## ARBORIST RESPONSE TO CITY REVIEW COMMENTS

REFERENCE: Arborist Response to City Review Comments RE: SUB22-009 (Cui Preliminary Short Subdivision)

SITE ADDRESS: 4833 90<sup>th</sup> Ave SE, Mercer Island, WA

DATE: 1/7/2024

Date:	08 / 20 / 2023
Stamp is not valid unless signed and dated	
Job Number:	220520 - PLE - 2211
DWG Date:	08 / 20 / 2023
Sheet No.	C - 5.0
	OF
	C - 7.0

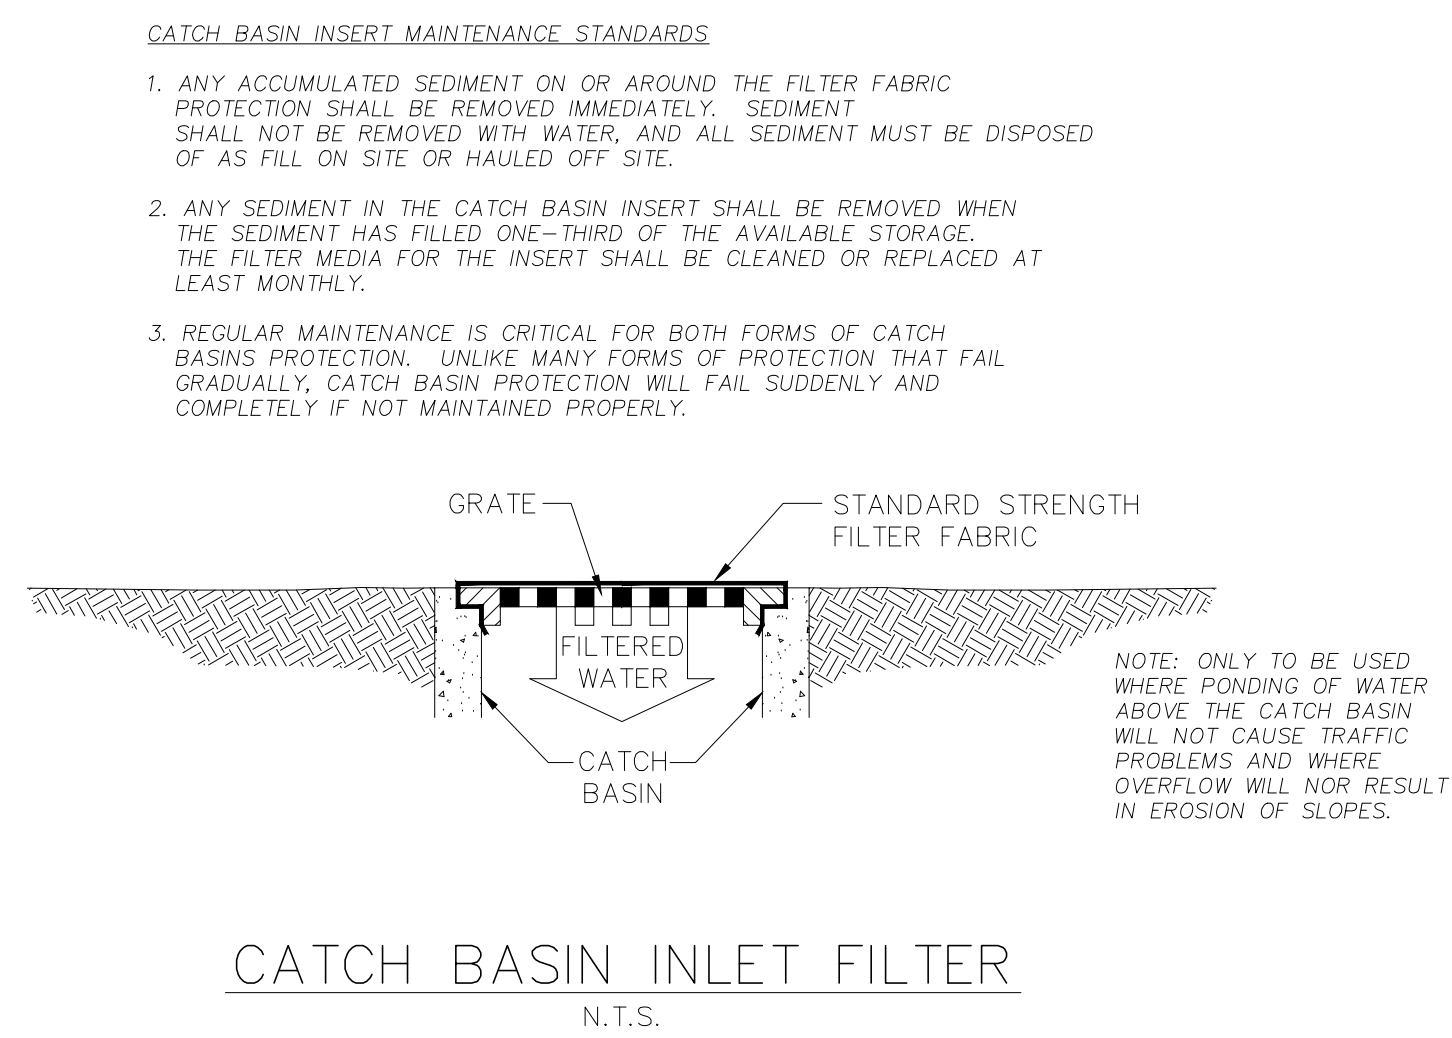
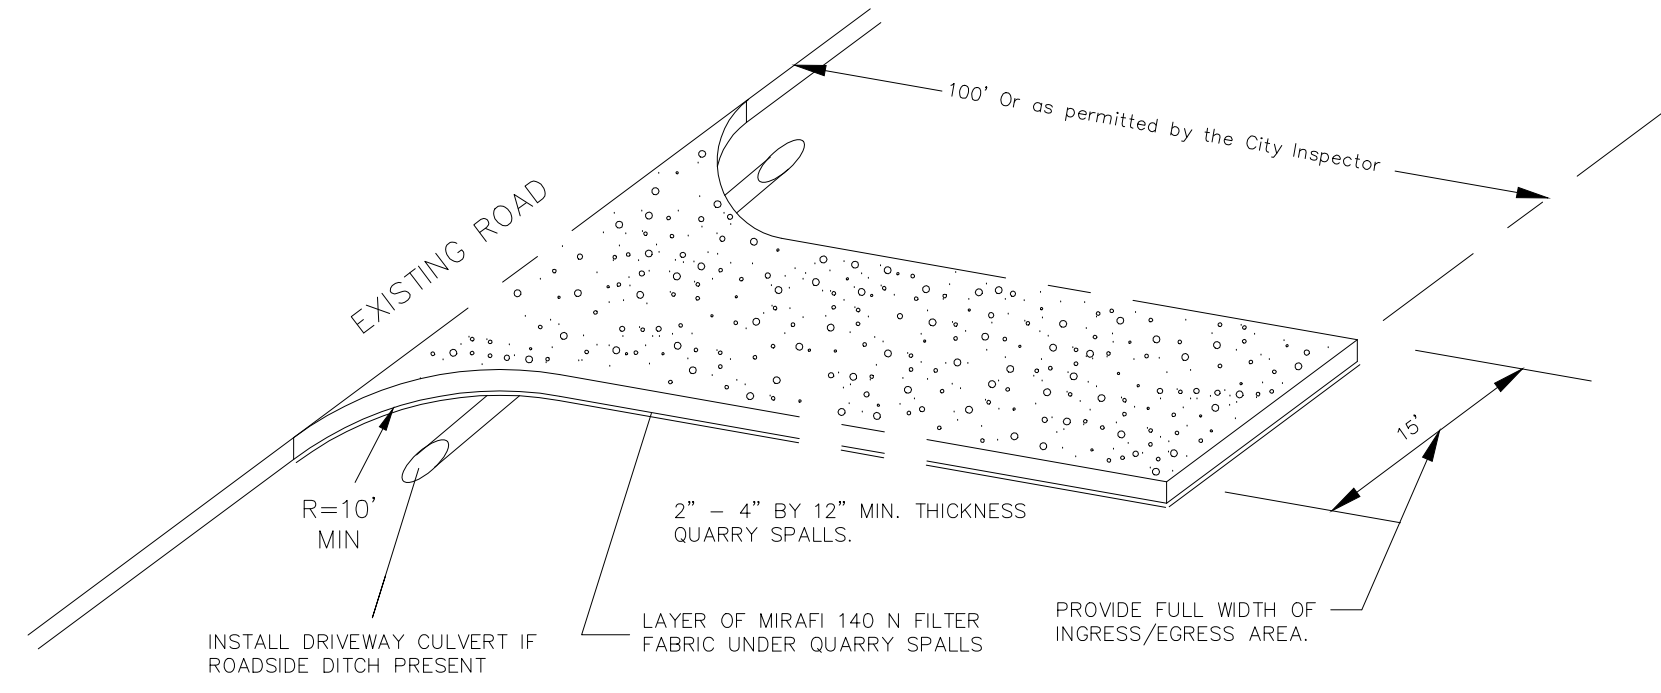
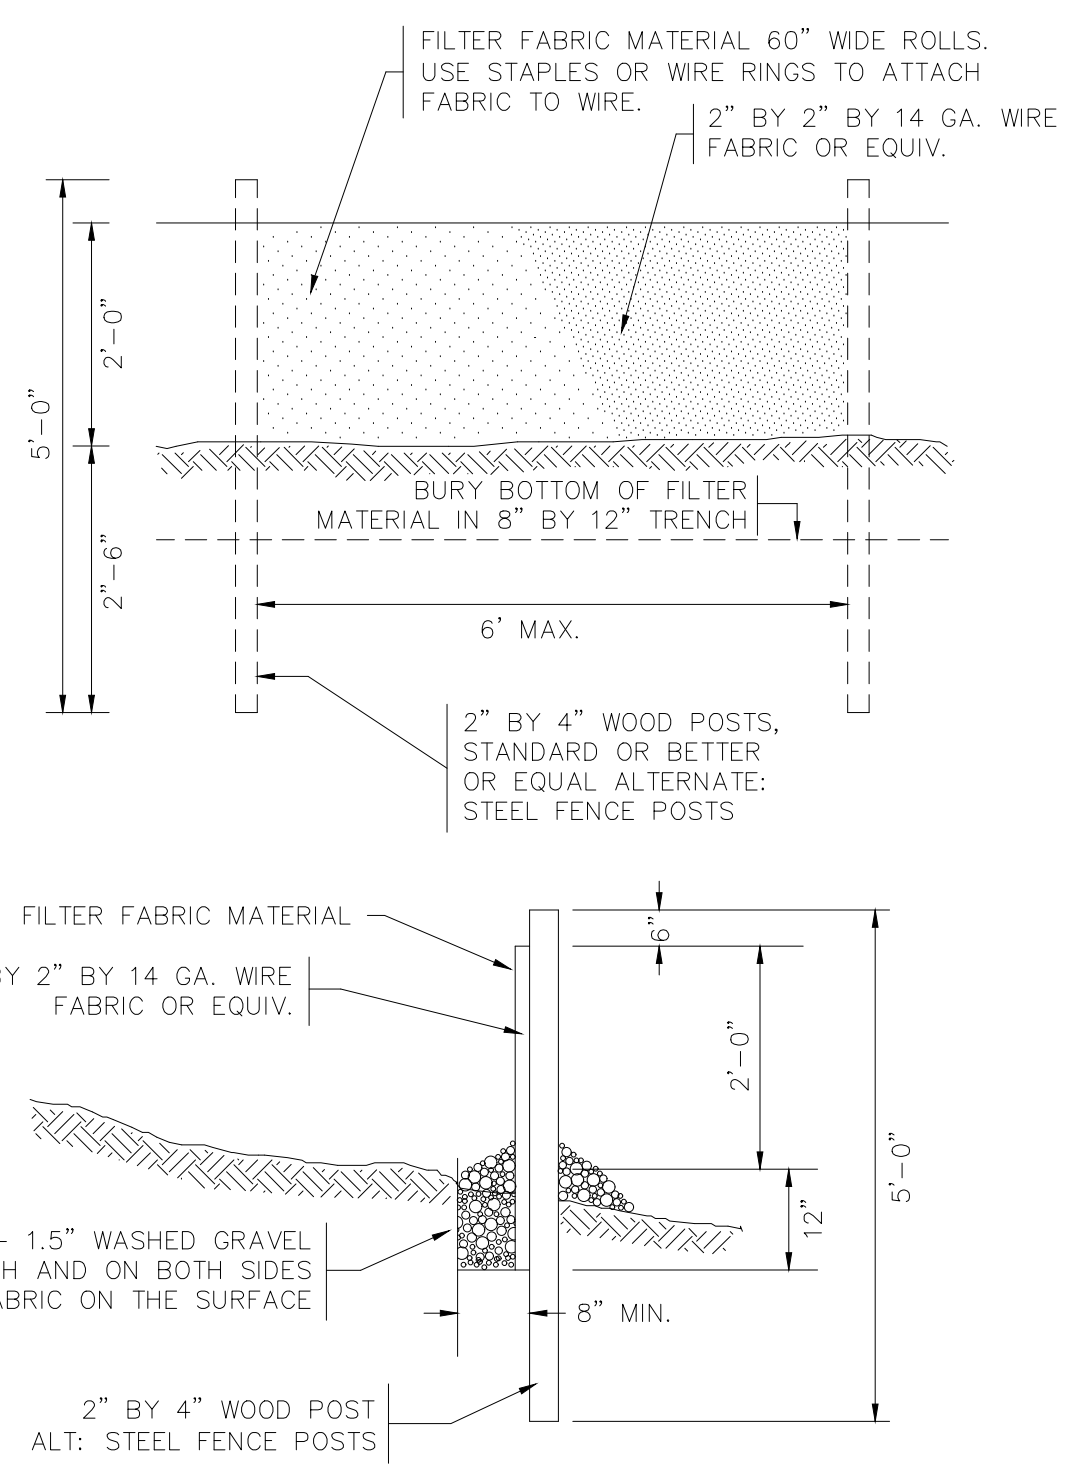
**1. The tree protection fencing needs to match on all plan sheets. Sheet TR-01 and sheet C-5.0 need to match with the arborist recommendations.**

Arborist Response: See the comment response provided by the Civil Engineer dated January 10<sup>th</sup>, 2024.
